From: William Simcock
Sent: 23 January 2019 12:30
To: DCAdmin
Subject: FW: Further Highways comments 92 New North Road.

From: Jamie Turner
Sent: 23 January 2019 10:07
To: William Simcock <William.Simcock@kirklees.gov.uk>
Subject: RE: 92 New North Road.

From: William Simcock
Sent: 16 January 2019 10:10
To: Jamie Turner <Jamie.Turner@kirklees.gov.uk>
Subject: FW: 92 New North Road.

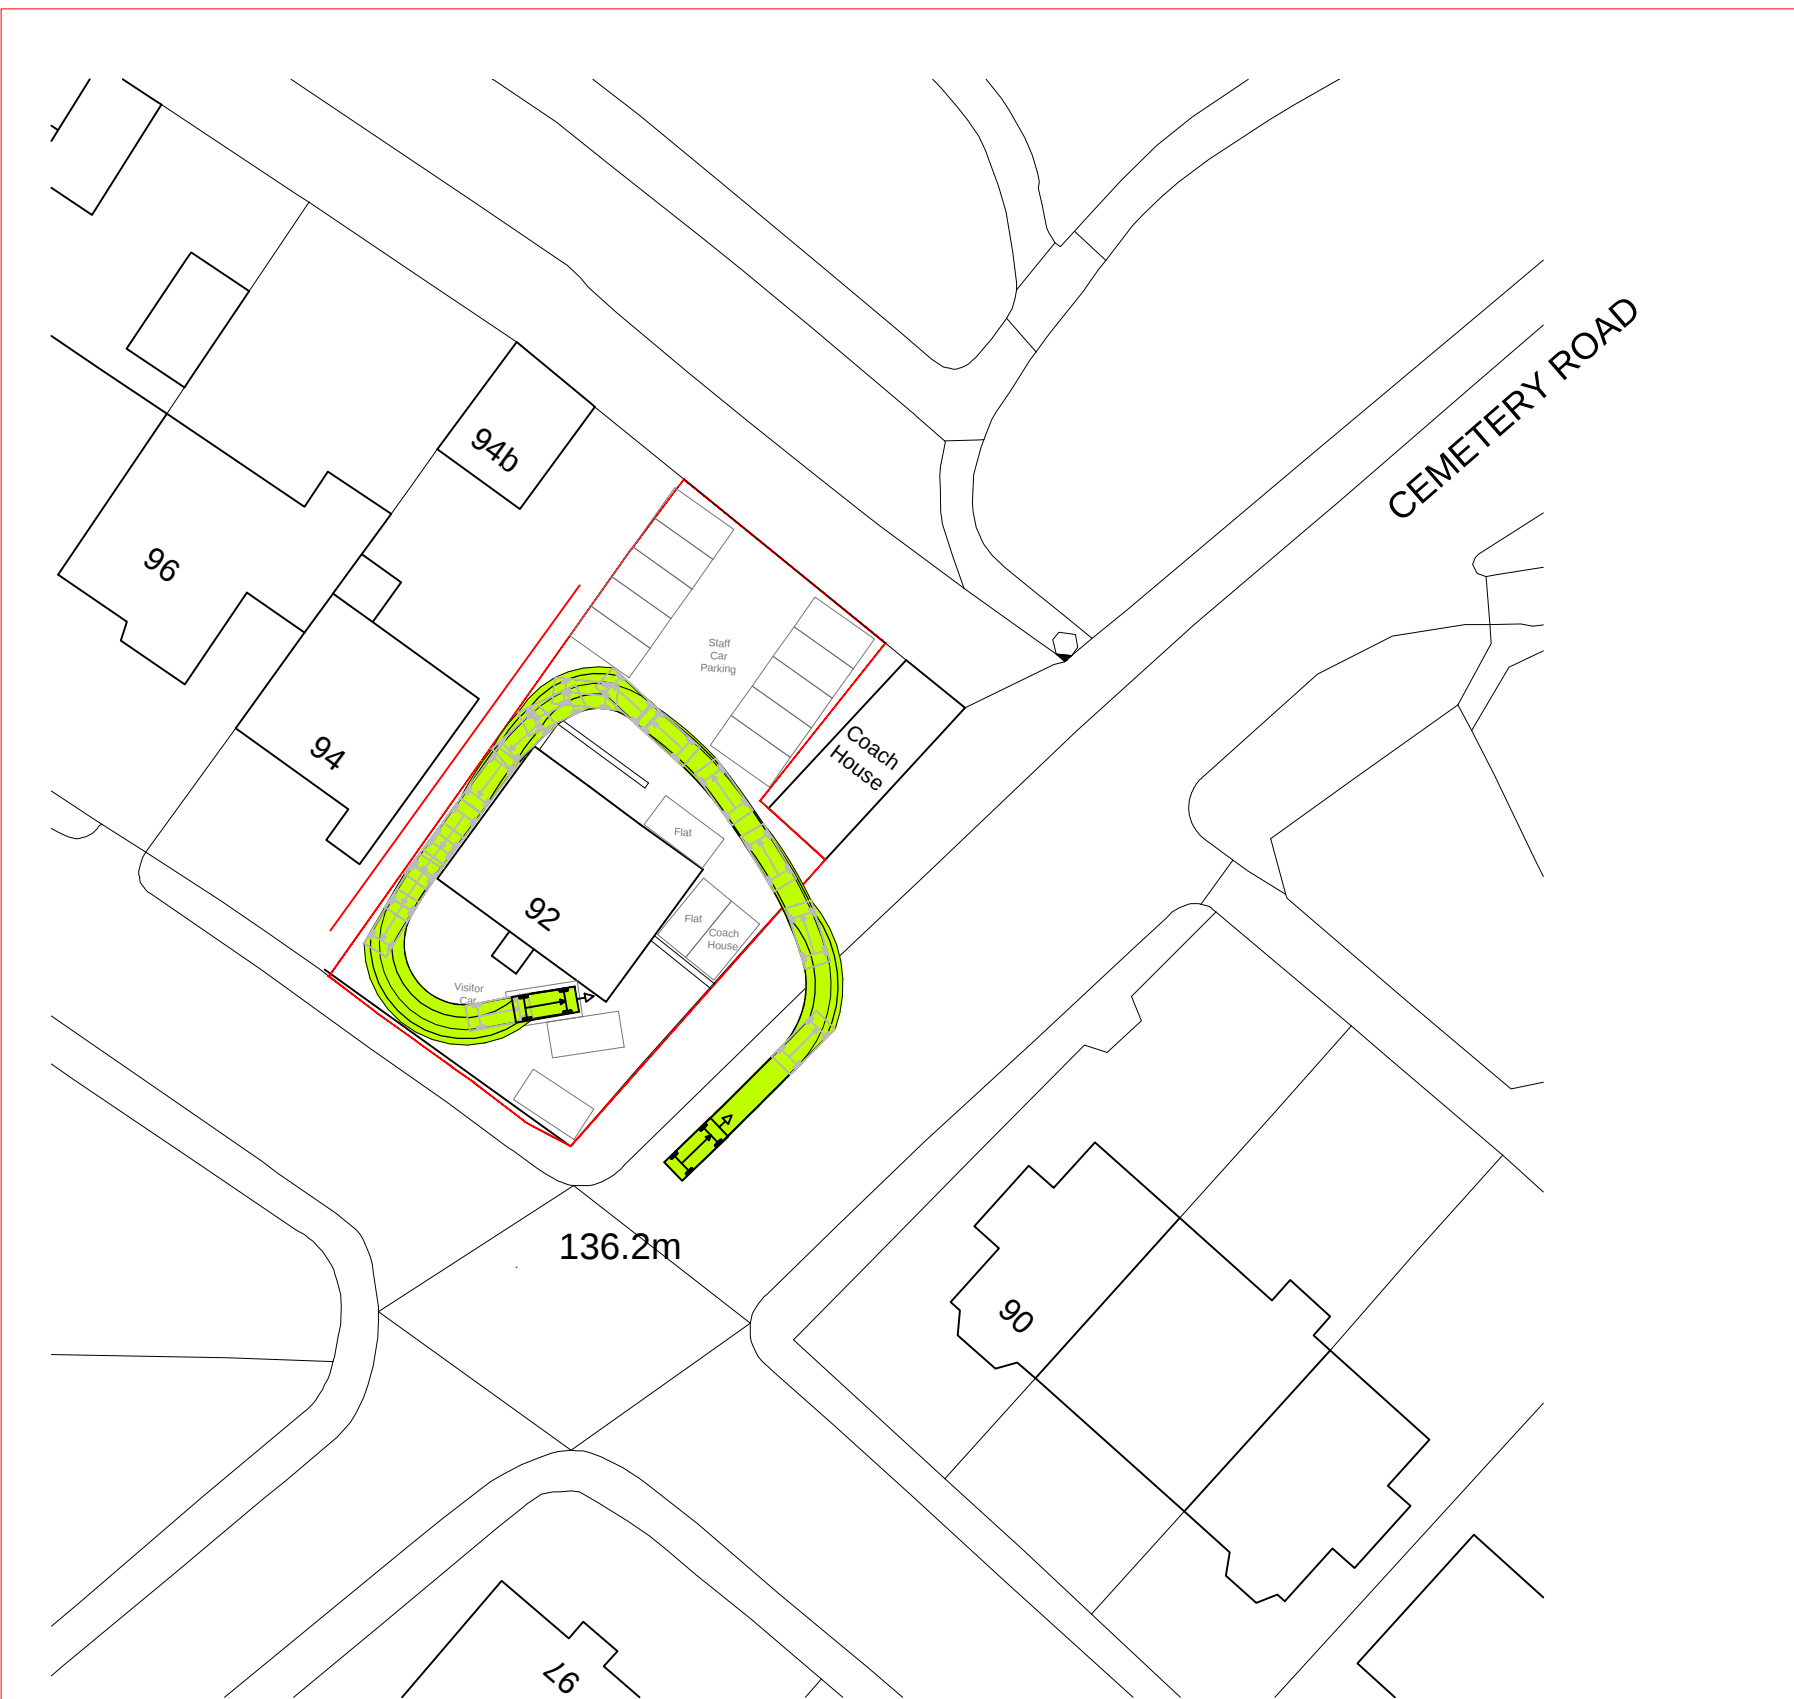
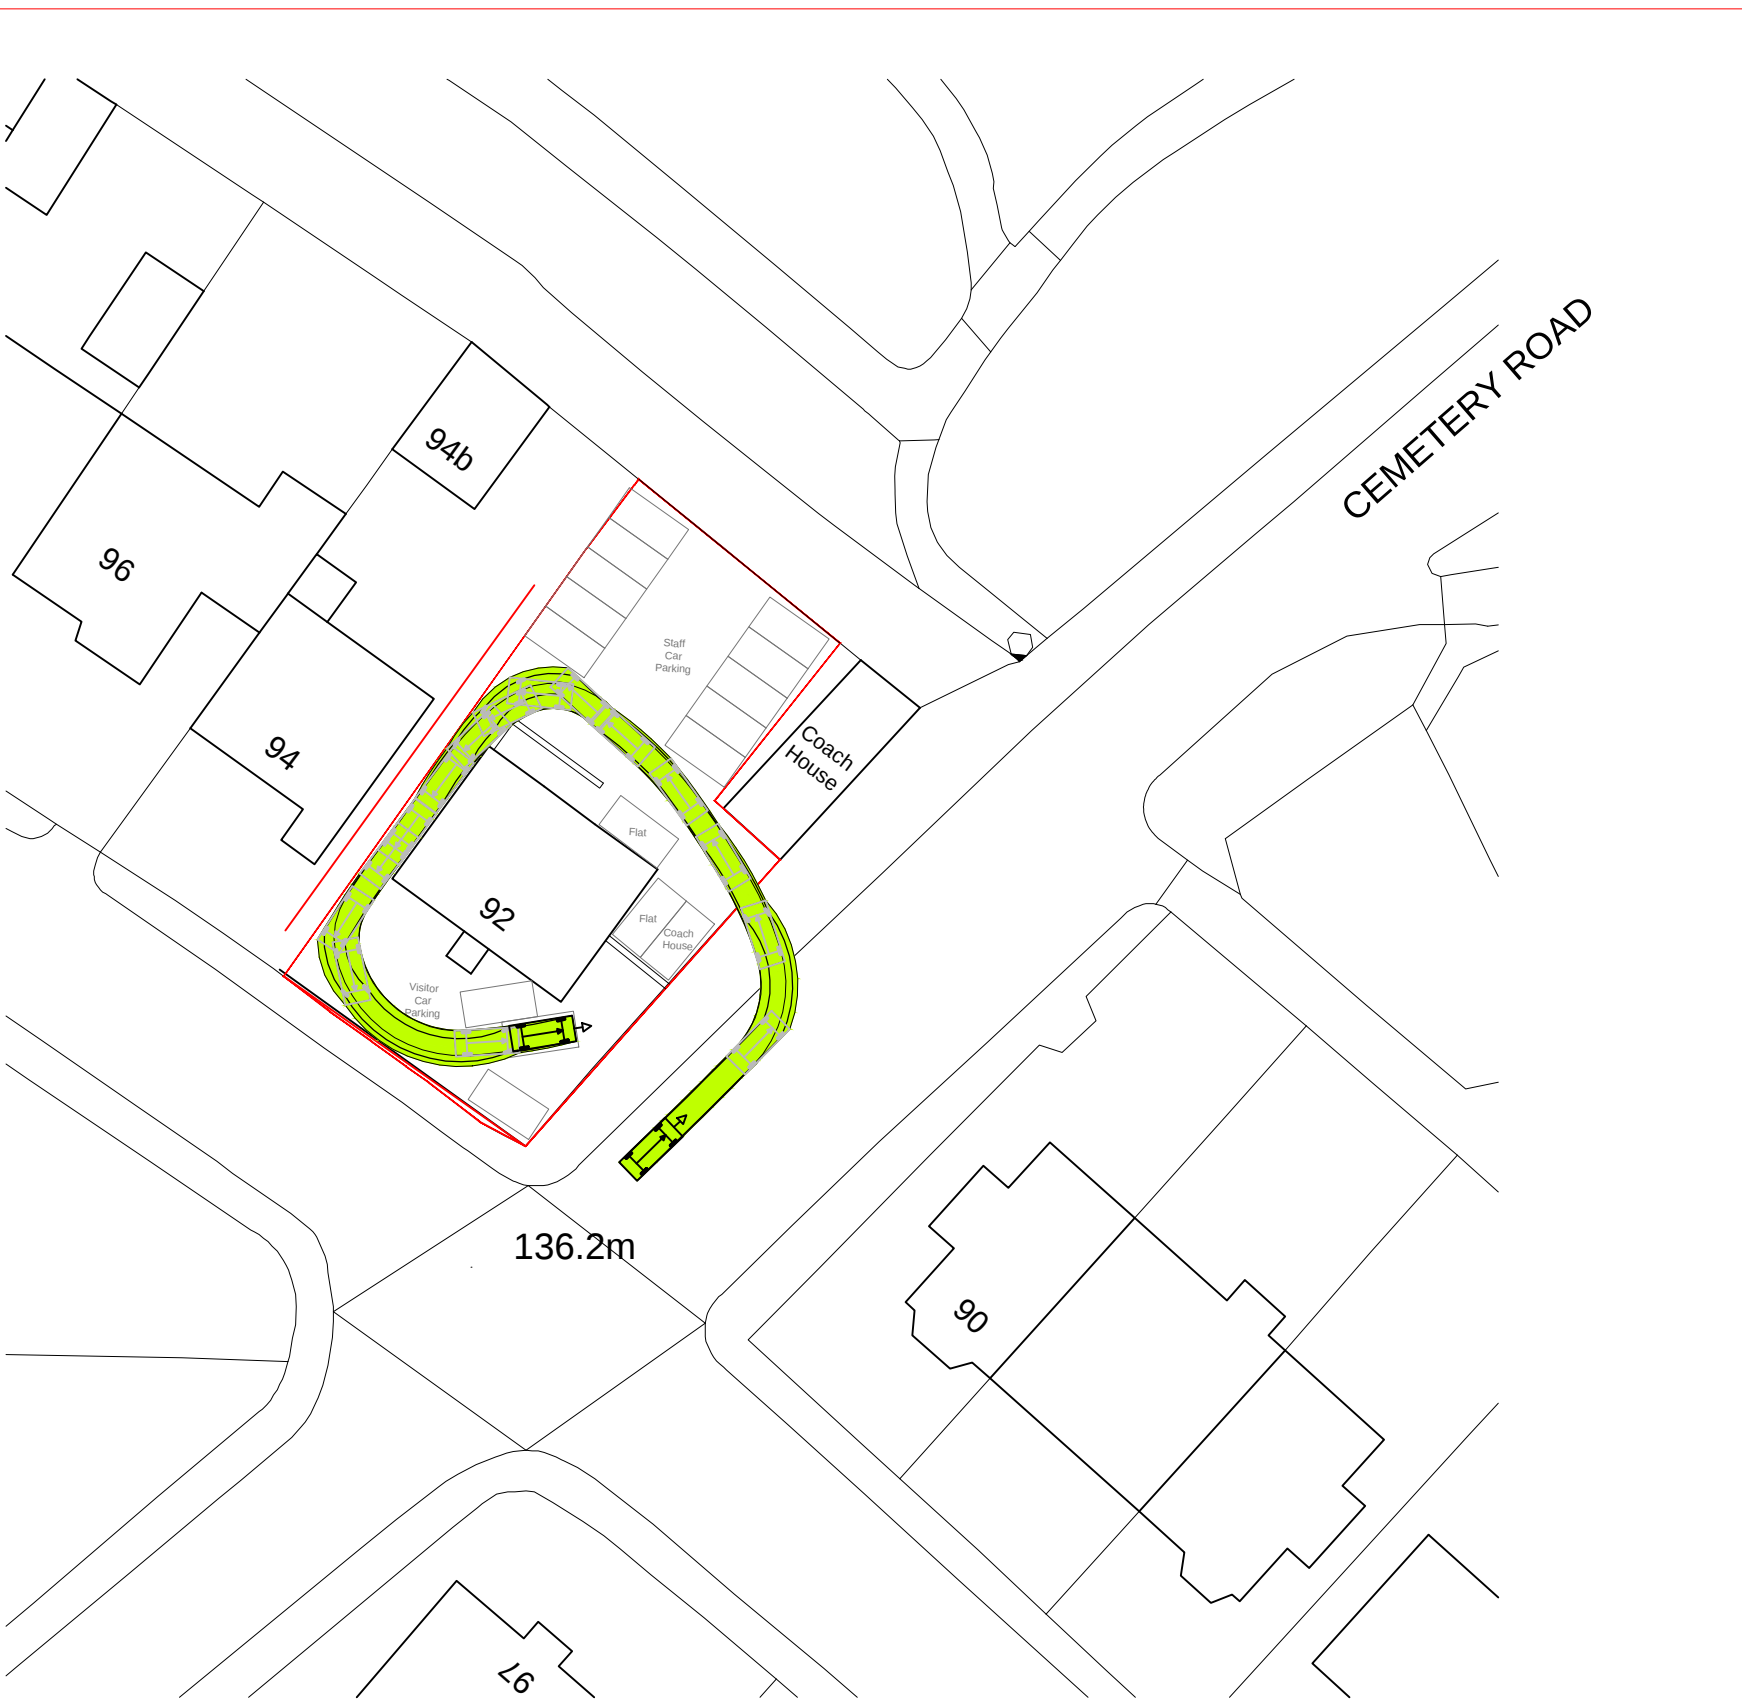
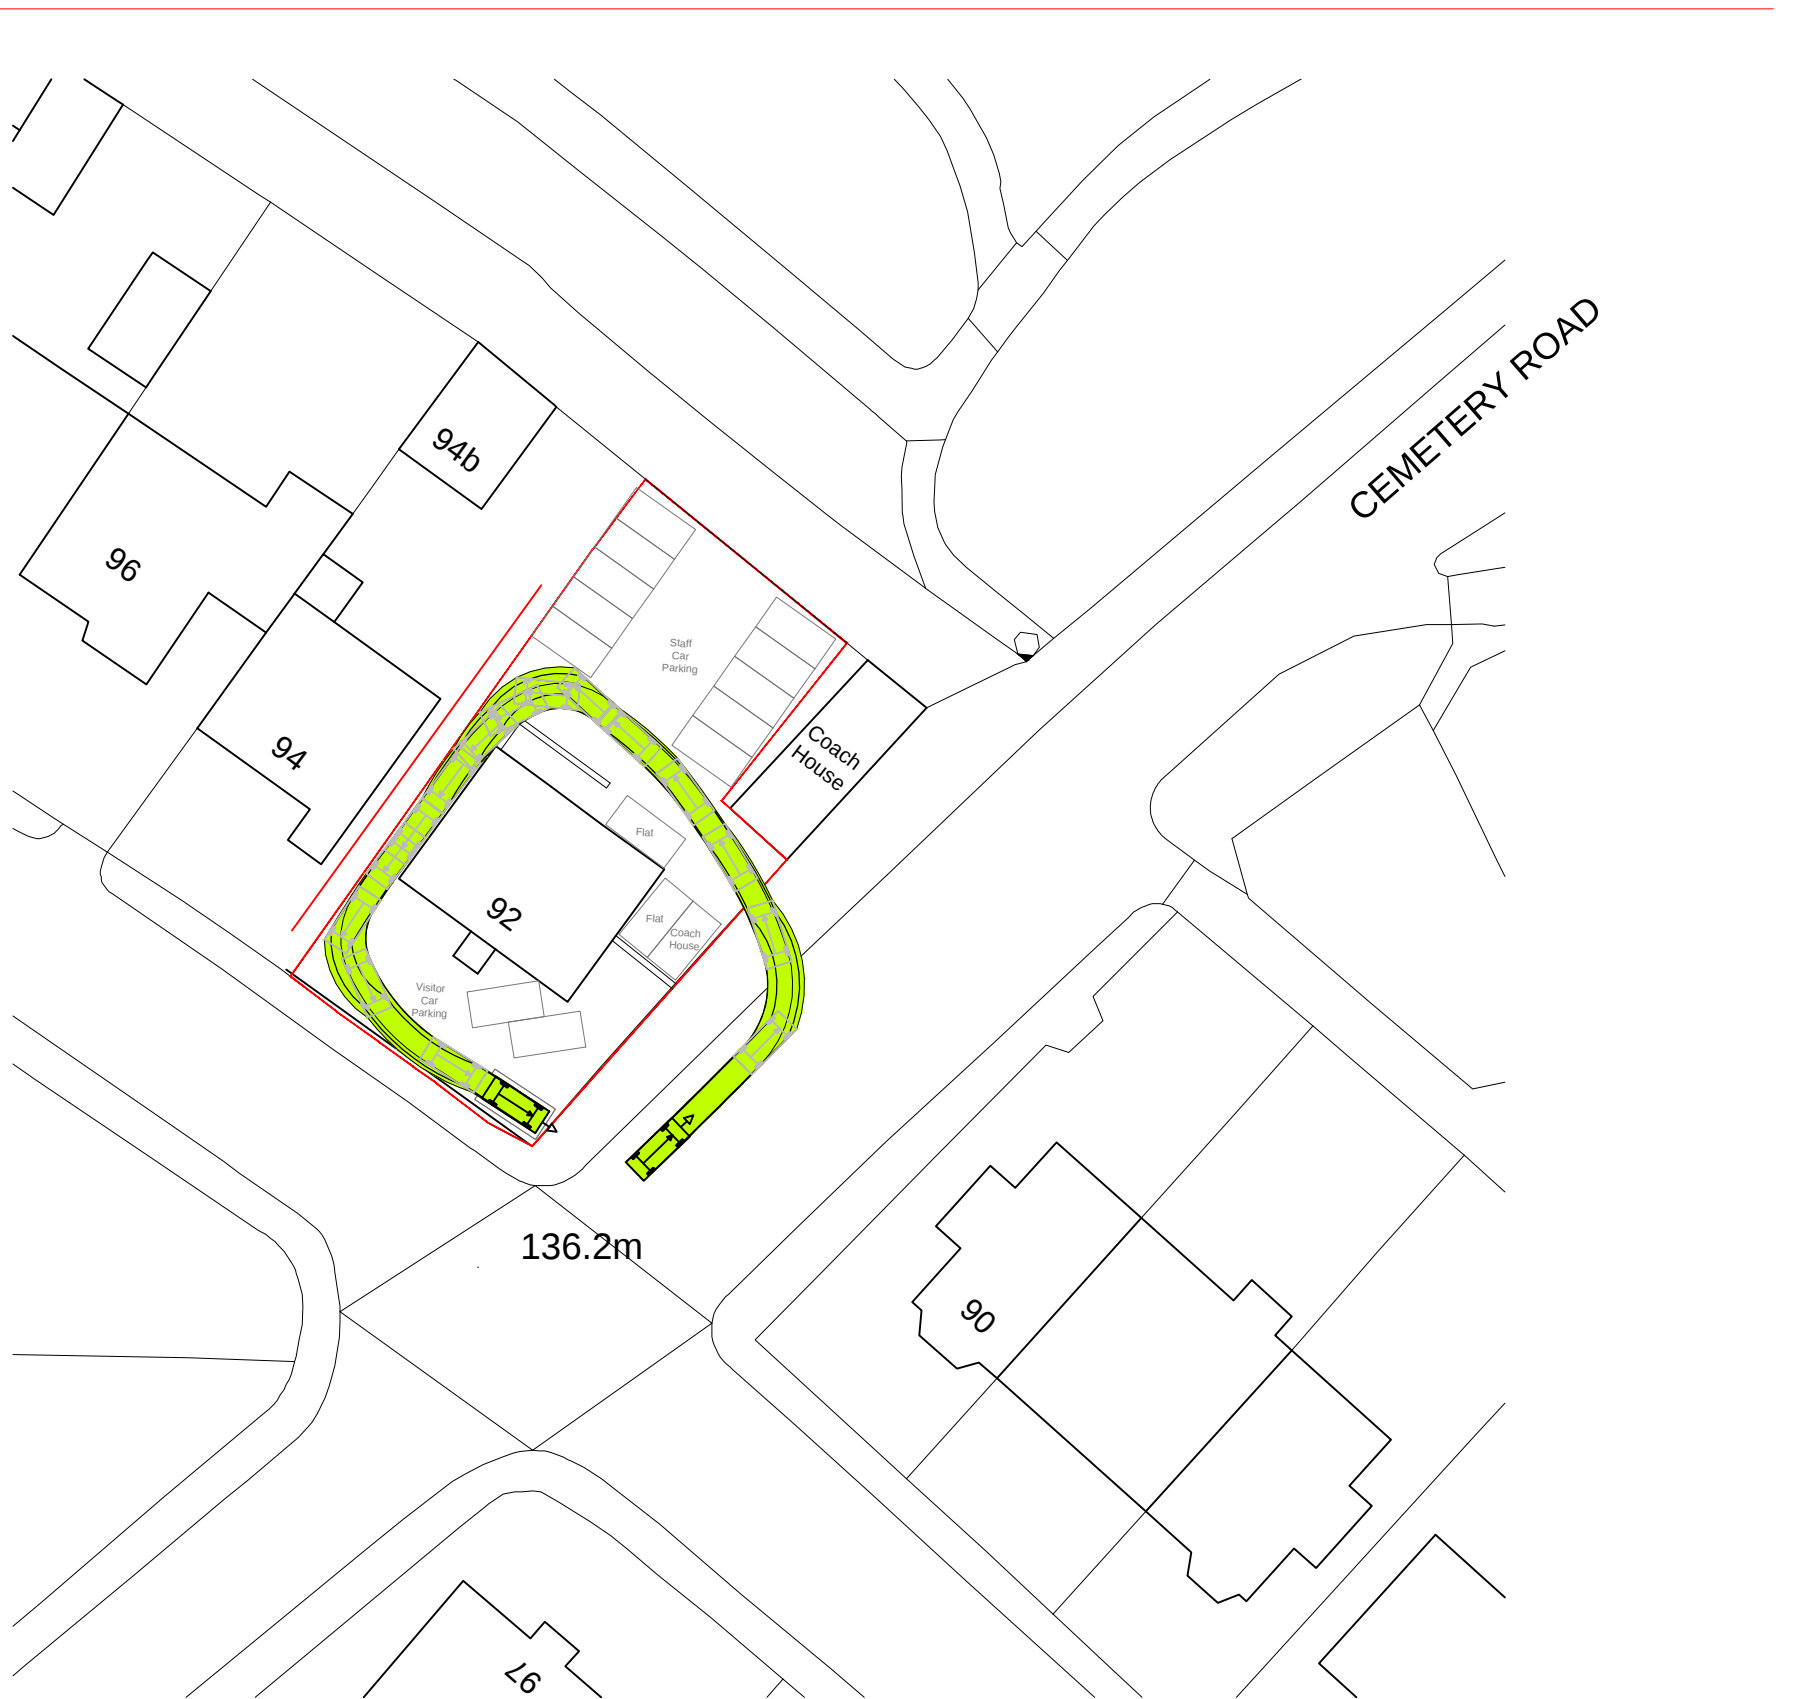
Given the location of the site, I feel the bays to the rear of the site would cover our minimum requirement for off-street parking provision. That said, I believe the front bays are accessible by a regular-sized car without crossing the red line boundary; there is approximately 2.3m of clearance even taking into account the chimney stack.

These are the latest swept paths. One parking space has been deleted. I think the number is more than adequate for a site with good public transport, but I would like your reassurance that the swept paths are okay.

Given the above, the scheme is acceptable from a highways point of view.
